Planning Act 2008 (as amended) – Chapter 2
Application by Highways England for an Order Granting Development Consent
for the A38 Derby Junctions
Adequacy of Consultation

**A38 Grade Separated Junctions Scheme
 Planning Act 2008 Section 42: Duty to Consult On Proposed Application**

Preliminary Environmental Information Report

Response on Behalf of Derbyshire County Council

**Little Eaton Junction Existing & Proposed Rights of Way Plan**

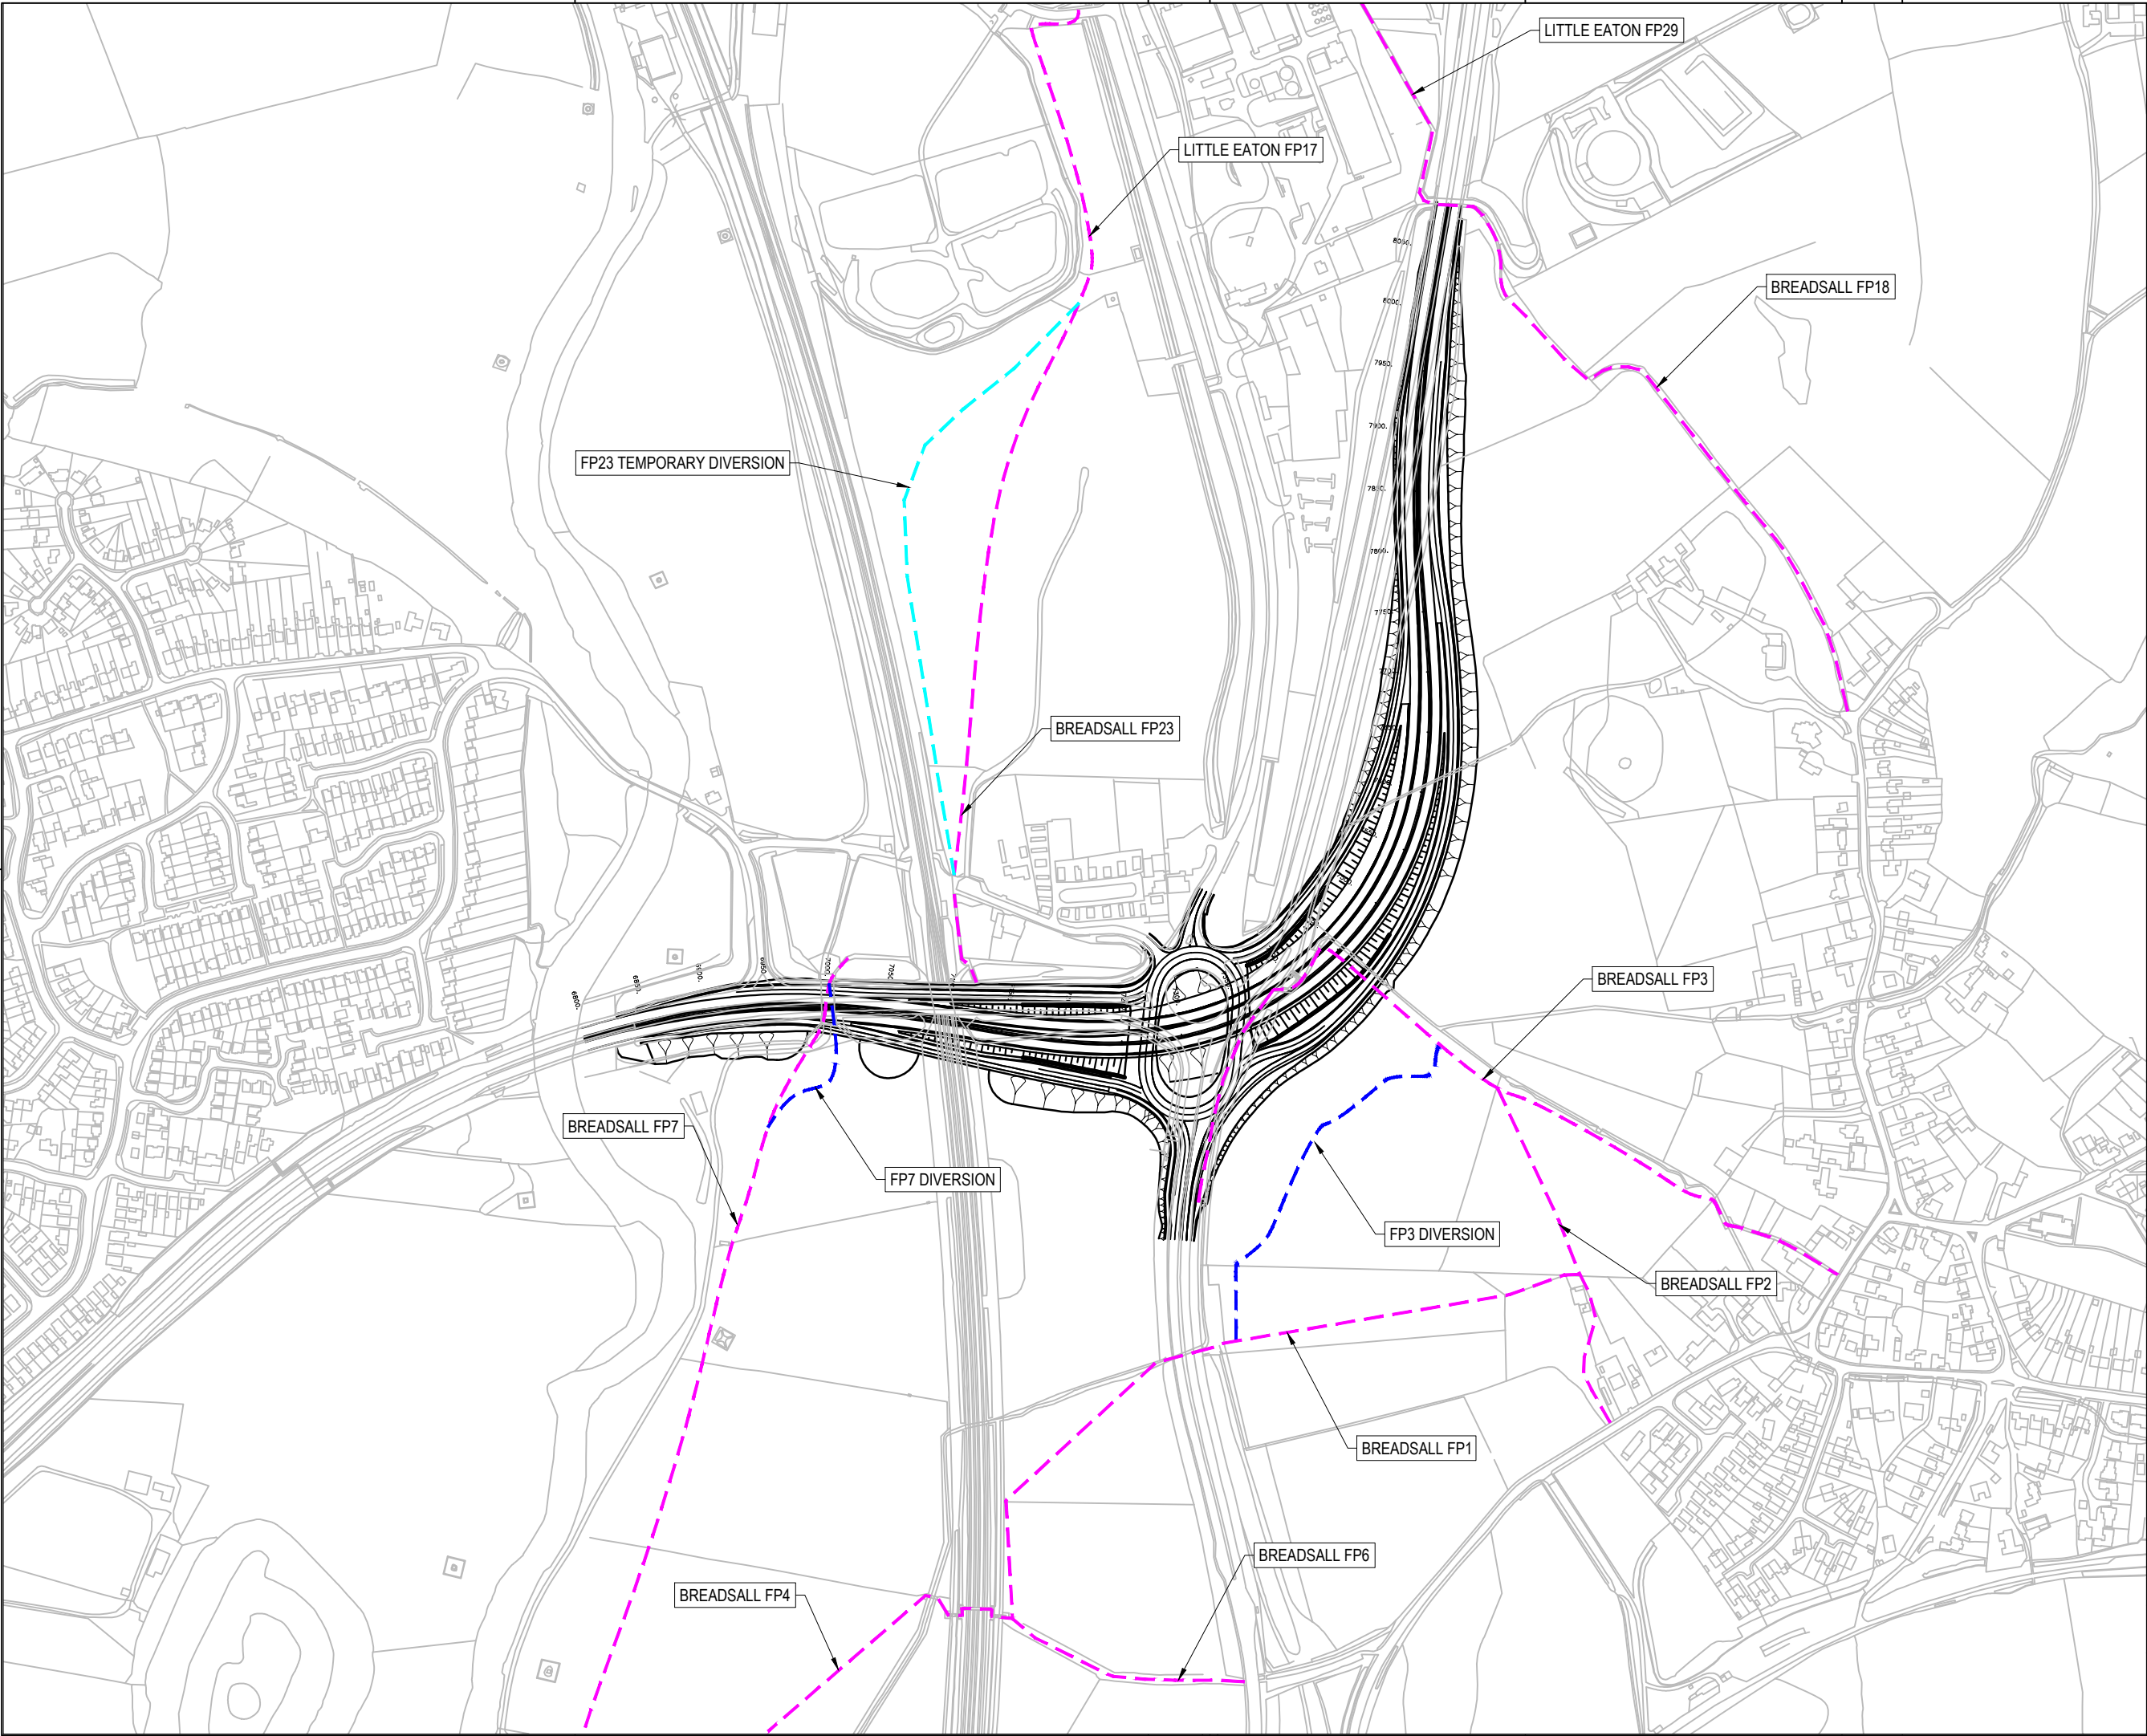
One of the issues which has been raised in the past is the current right of way which comes out of Breadsall village (*Little Eaton Junction Consultation Brochure Drawing*) shown as the Dam Brook trail which runs from the village towards the A38 and then follows the current alignment of the A61 around and comes out at the side of the A61 just after the end of the ARMCO barrier. There are worn sections of grass in the middle of the A61 where pedestrians have been standing in the past to cross over the A61. It would appear that the route is used by people wishing to access the northbound bus service at the nearby stop provision on the A61.

One of the possible ideas under consideration was to divert the right of way (Dam Brook) from the back of the village at a perpendicular angle straight to the A61 edge (shortest route), however the design layout of the scheme set out in the Consultation Brochure is showing it being diverted around the back of the surface water management ponds and coming out at a similar location at the A61 to where the current informal crossing type arrangement exists. Irrespective of which route the path takes from Breadsall village, it will likely be constructed to a suitable standard i.e. top trek type material with defined edging. It is likely that should the right of way be of a good standard it will encourage an increase in footfall to and from Breadsall village as it will be an improvement on the current provision. An issue in respect of the current proposed arrangement set out in the Consultation Brochure is that the path would come out in close proximity to the roundabout and as the road is of a higher speed limit, vehicles exiting the roundabout/A38 would enter the A61 and be in potential immediate conflict with pedestrians and other vulnerable road user groups crossing at this point, in addition to which at peak times if a controlled crossing was on red for vehicles we could have potential for queuing back onto the roundabout.

The proposals do not make reference to whether the realignment of the Dam Brook will be of a sufficient width that it could accommodate both pedestrians and cyclists. Nor does it make reference as to what standard of construction it will be. At this point on the A61, it is evident that the ability to then cross the A61 Alfreton Road to access the western side of the road for recreational purposes (walking, cycling) travel purposes (north bound bus stop and its services) or to pursue a route into Little Eaton village to the South, is restricted.

Derbyshire County Council as the Highway Authority recognises the difficulty in people being able to safely cross the A61 and the Authority has received many communications from residents and the Parish Council of Breadsall village with regard to this matter. Officers have met with Highways England in respect of the scheme for the A38 and in particular the area around the Little Eaton roundabout. Derbyshire County Council has made representation through the consultation process for this scheme that it would wish to see the implementation of a pedestrian crossing near to the Croft Lane access onto the A61. This would be of a sufficient distance from the roundabout and that approaching vehicles would have sufficient

time and distance to react when the crossing point is activated, and reduce the potential for vehicles to be queuing back onto the A61/A38 junction. To facilitate a scheme of this nature would require the need for the construction/continuation of the Dam Brook Trail down the Eastern Side of the A61 from the proposed current end of the facility near the ARMCO barrier as a footpath construction to connect to the existing Bus Stop provision and into the Croft Lane existing cycle/pedestrian footpath. This would allow for a safe and suitable crossing point that connects both the north and south bound bus stop provision on the A61 and the new shared pedestrian/cycle path on the western side of the A61 that Derbyshire County Council are to commence construction on in February 2019.
